Ref: 6/2017/2594/LB
Date: 03/01/2018

HISTORIC BUILDINGS AND CONSERVATION ADVICE

RE: Oshwal Centre, Coopers Lane Road, Northaw, Potters Bar, EN6 4DG

The application is for internal alterations to Hook House at the Oshwal Centre, Northaw.

GROUND FLOOR PLAN AS PROPOSED

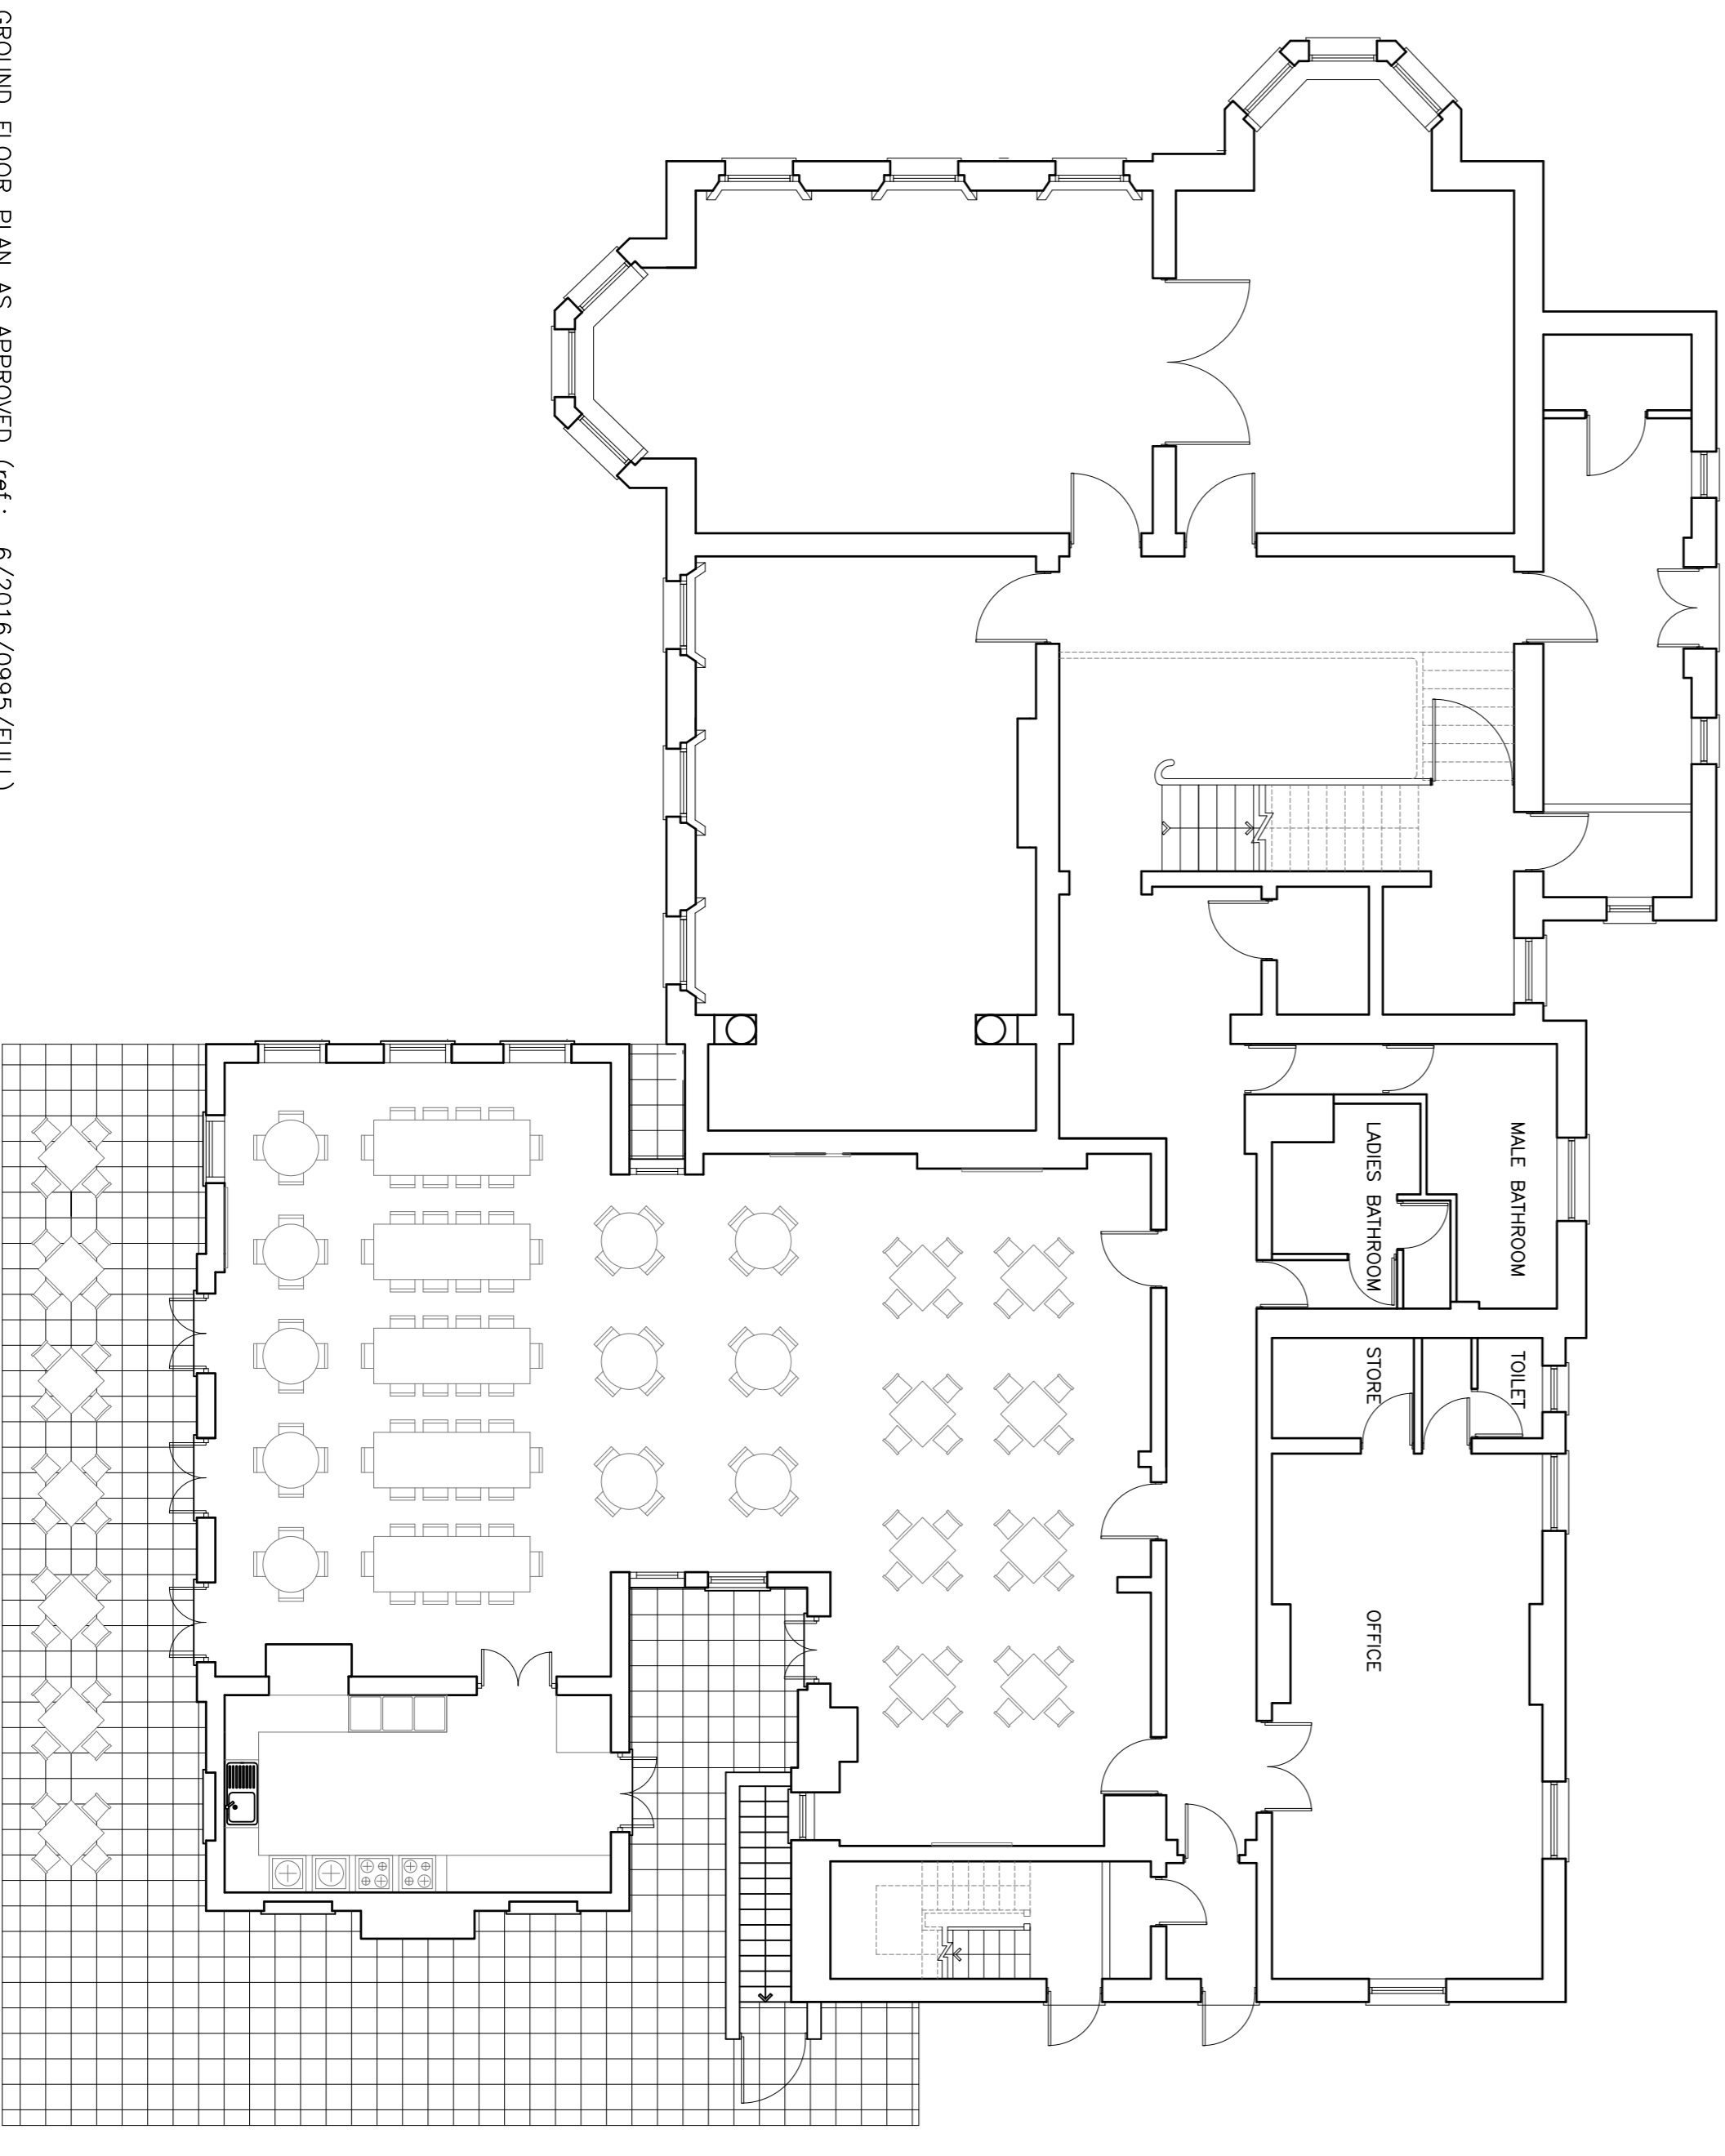
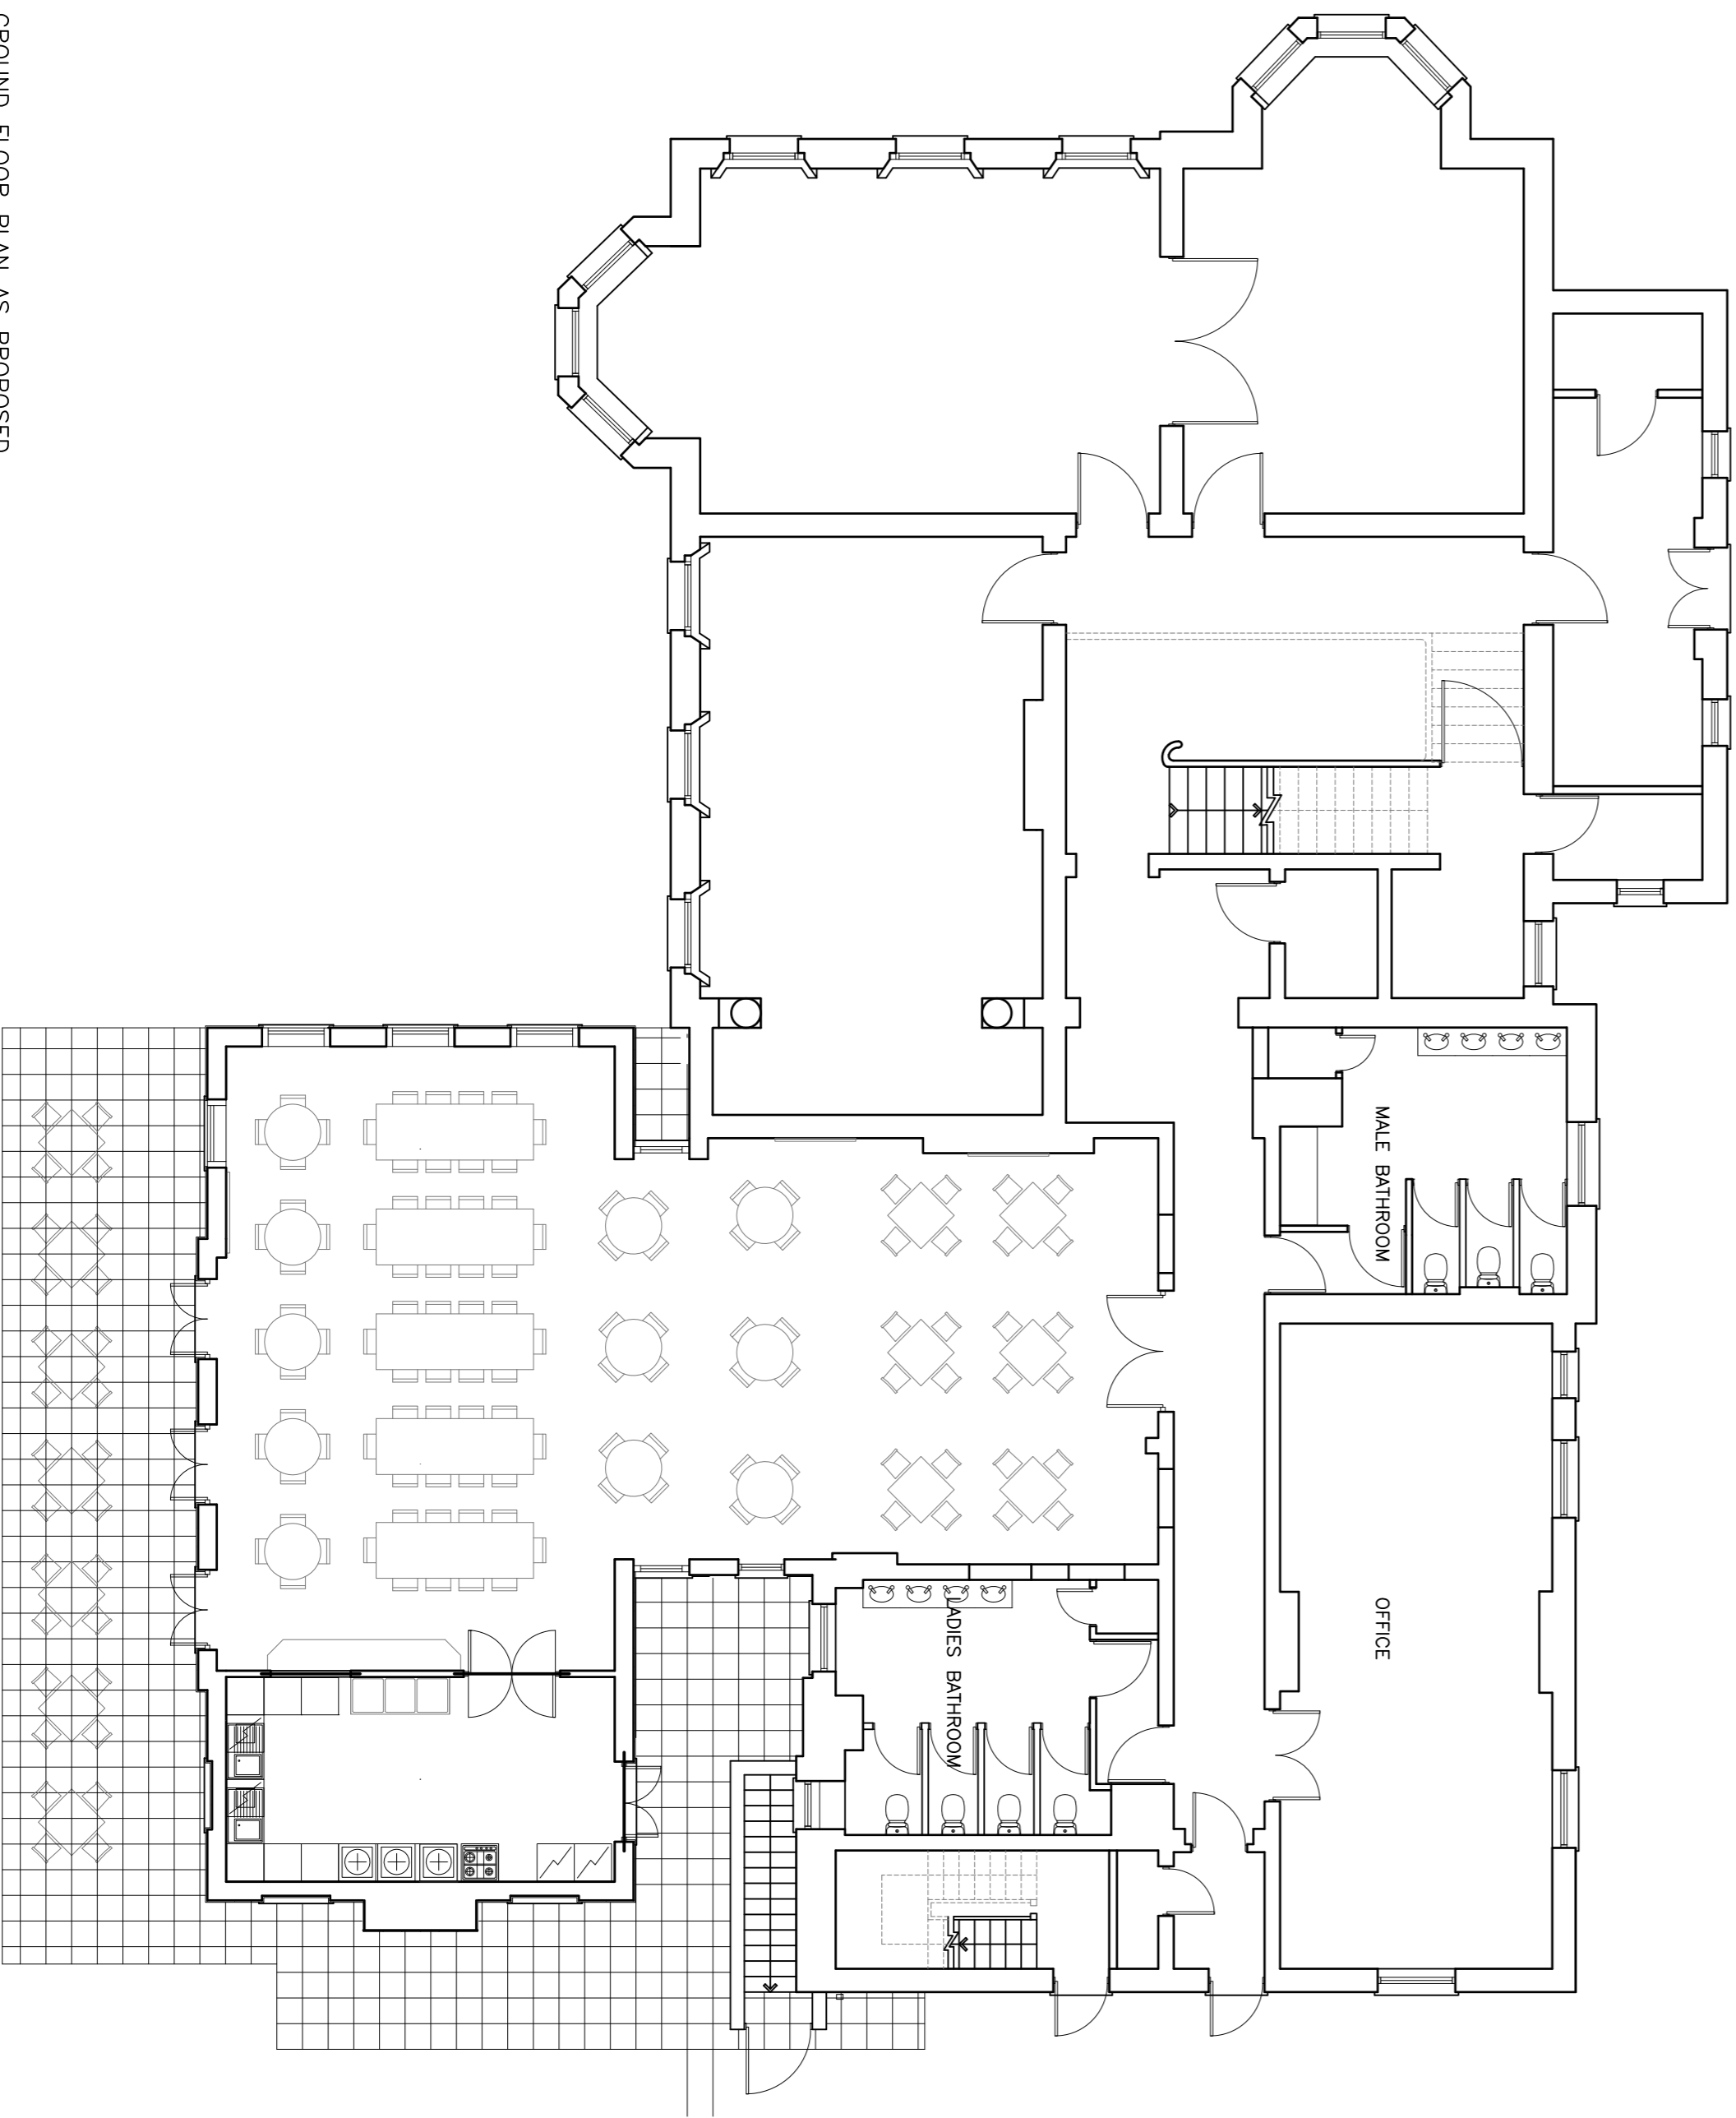
The proposed works within the dining hall/canteen comprise the infilling of the existing hatch and doorway between these two rooms and the insertion of lightweight partition walls within the canteen space to create a female bathroom. It is considered that these works would not have a significant impact on the special interest of the listed building. It is also proposed to insert double doors within the south wall of the dining hall and to infill the two existing doorways. This would involve a minimal loss of historic fabric and it is considered that this element of the proposals could be reconsidered to retain access via the two existing doors.

It is also noted that the double doors between the proposed kitchen and dining area within the new extension have been amended to double swing doors and it is considered that traditional double doors would be more appropriate within the listed building.
